CUMBERLAND
CITY COUNCIL

Ref: OA2020/0013

Subject: Request for comments-State Significant Development (SSD)
Application No: SSD-10407
Property: 14 & 16 Kiara Crescent YENNORA NSW 2161
Proposal: Ministerial Consent - Expansion of existing liquid waste treatment facility for increasing processing and storage quantities and hours of operations to 24/7

Figure 2.1. Swept paths for heavy vehicles accessing the site at 14- 16 Kiora Crescent, Yennora. NSW Surveys PTY LTD, 8/11/19.

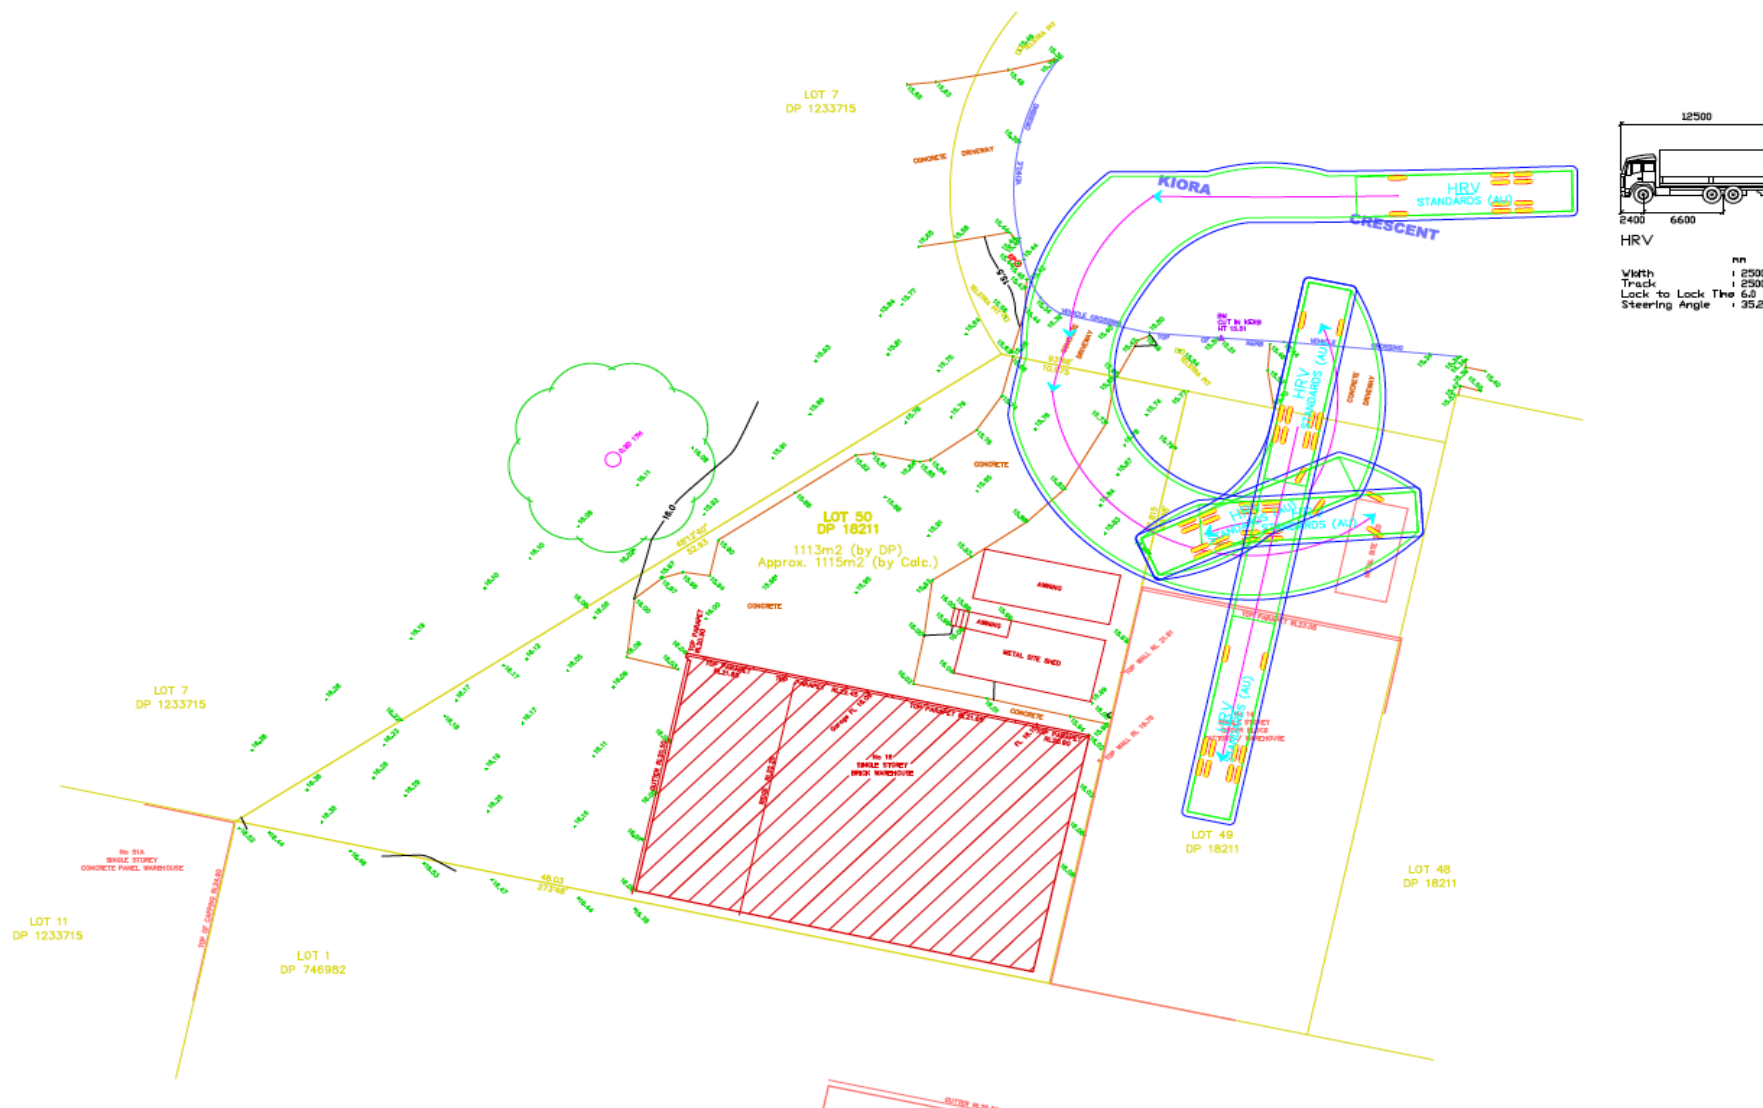
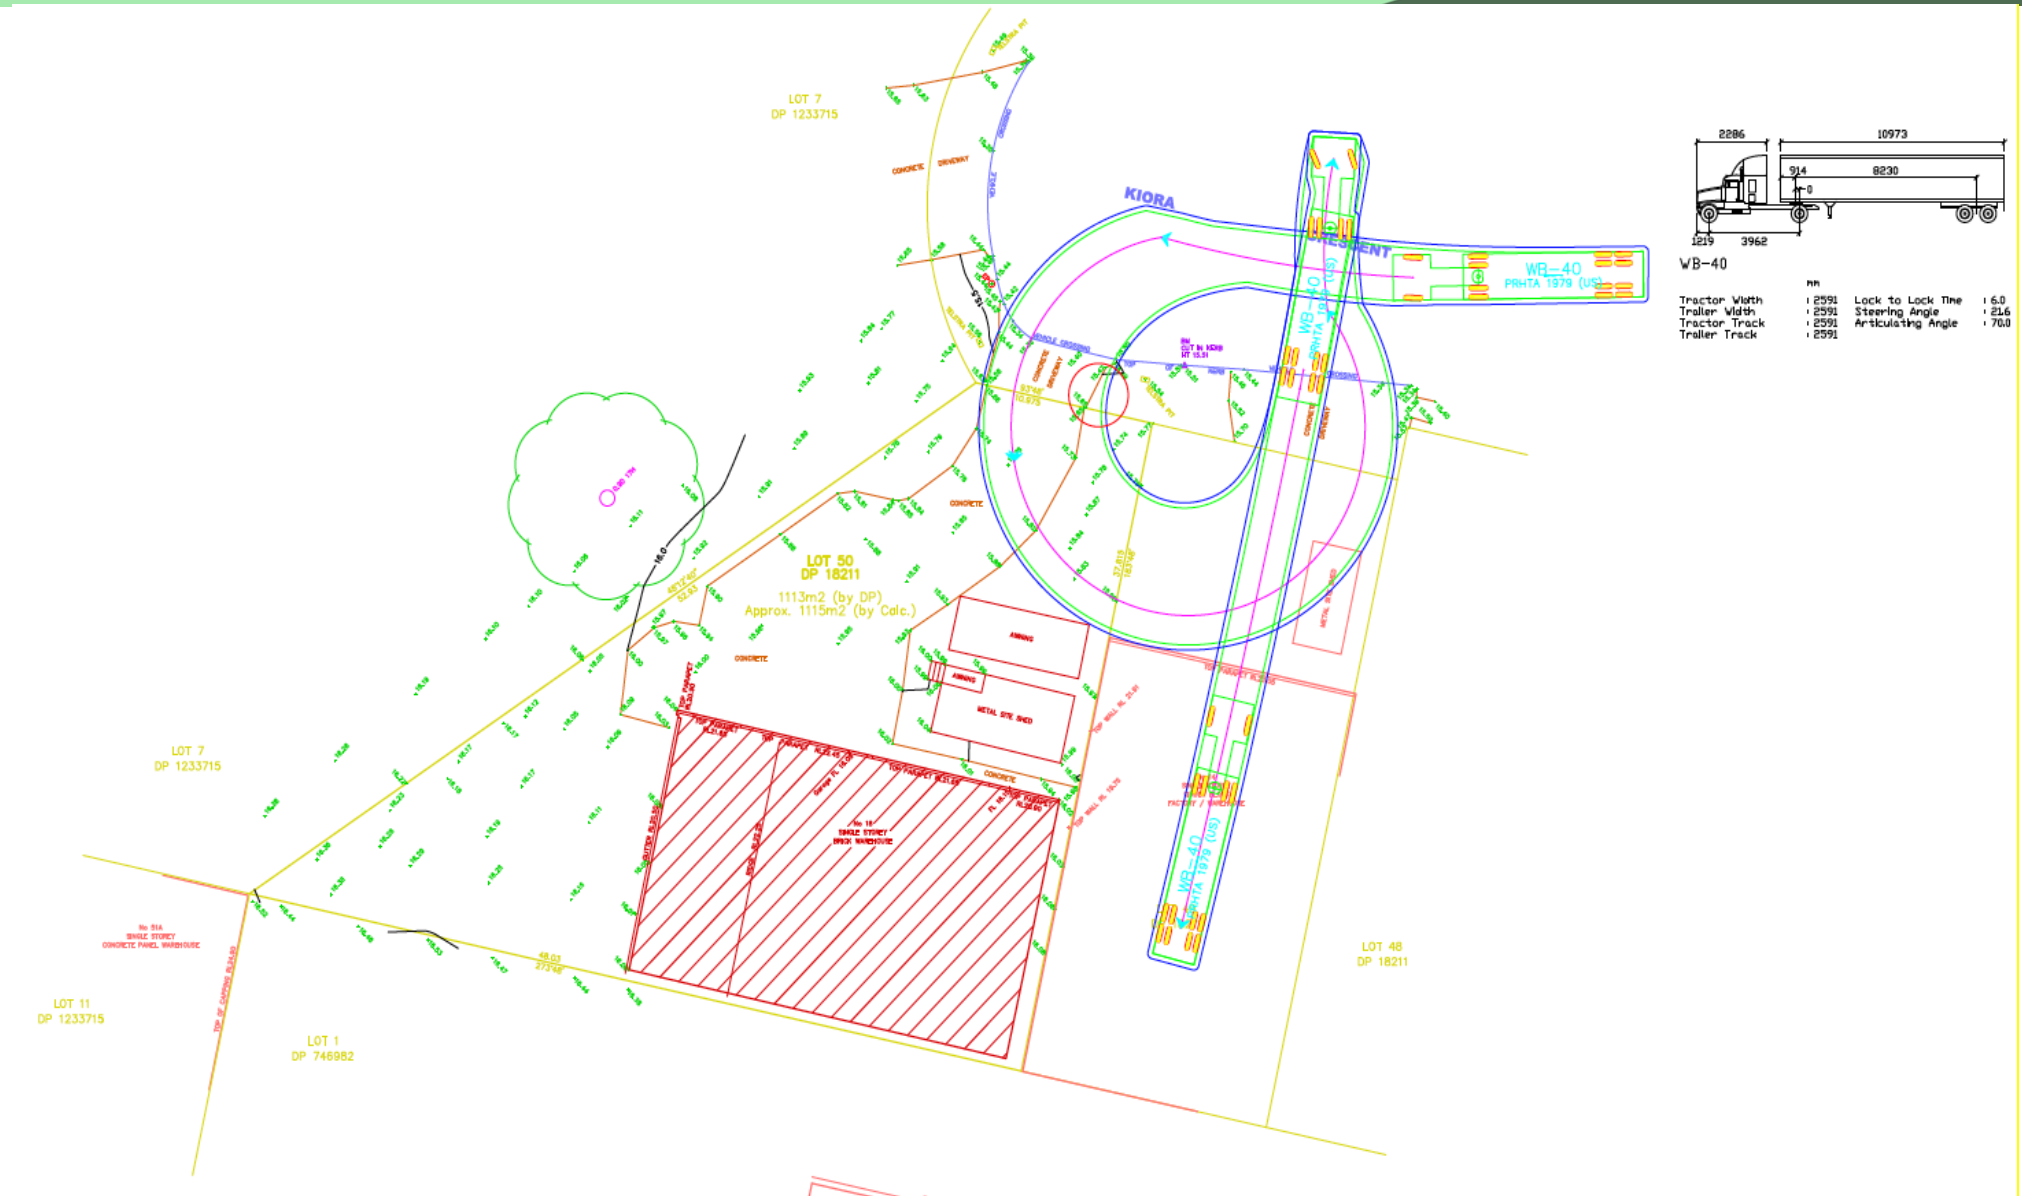
- a) The 10.0m truck used in the swept path analysis is not a standard truck that is defined in Australian standard AS2890.1. Further, the swept path clearance turning with 12,5 standard turning circle must be used.

- b) The manoeuvring and turning of the vehicle must be completed within the site and must not cause encroachment into nature strip or the footpath. The swept path diagrams demonstrate otherwise with the encroachment into nature strip.

- c) Sufficient swept path diagrams must be provided to demonstrate that the turning and manoeuvring of the truck is possible for all, entry and exit for both processing plant. The swept path must demonstrate with a truck in the waiting/stand-by bay.

- d) Further, the Truck swept path diagram also indicates the runover into the structure (entrance door jamb) and the car space for 16 Kiora Place.
- e) Reverse manoeuvring in Council's land is not acceptable. It will compromise the safety. Vehicles should enter and leave the site in a forward direction.

- f) Multiple point turn (more than 3 points) will result in additional time for the turning and manoeuvring thus overlapping with the arrival of another vehicle (truck) and causing obstruction and delay. Enough space must be provided for manoeuvring and turning with the minimum delay. The proposed 4-point turn truck manoeuvring movement is not acceptable. Manoeuvring shall be limited to three-point turn.

- g) Parking and loading design must comply with Australian standard AS2890.1 and AS2890.2. Further the design vehicle into consideration for the swept path analysis must be as per AS2890.2 (not UK standard as noted on the swept path diagram).
- h) The estimated peak hour traffic generation of the waste trucks is based on the assumption that the processing plant is operational 24 hours a day, 7 days a week. However, this is subject to the approval of the proposed operational management plan. Any variation to the operational hours will result in the increase in the frequency of the truck traffic. In such case the following must be complied:
 - (i) The traffic impact report must be revised and demonstrate how this will not result in adverse impact.
 - (ii) Additional facility/ area for holding the waste
 - (iii) Additional facility/area for the trucks waiting for unloading the waste.
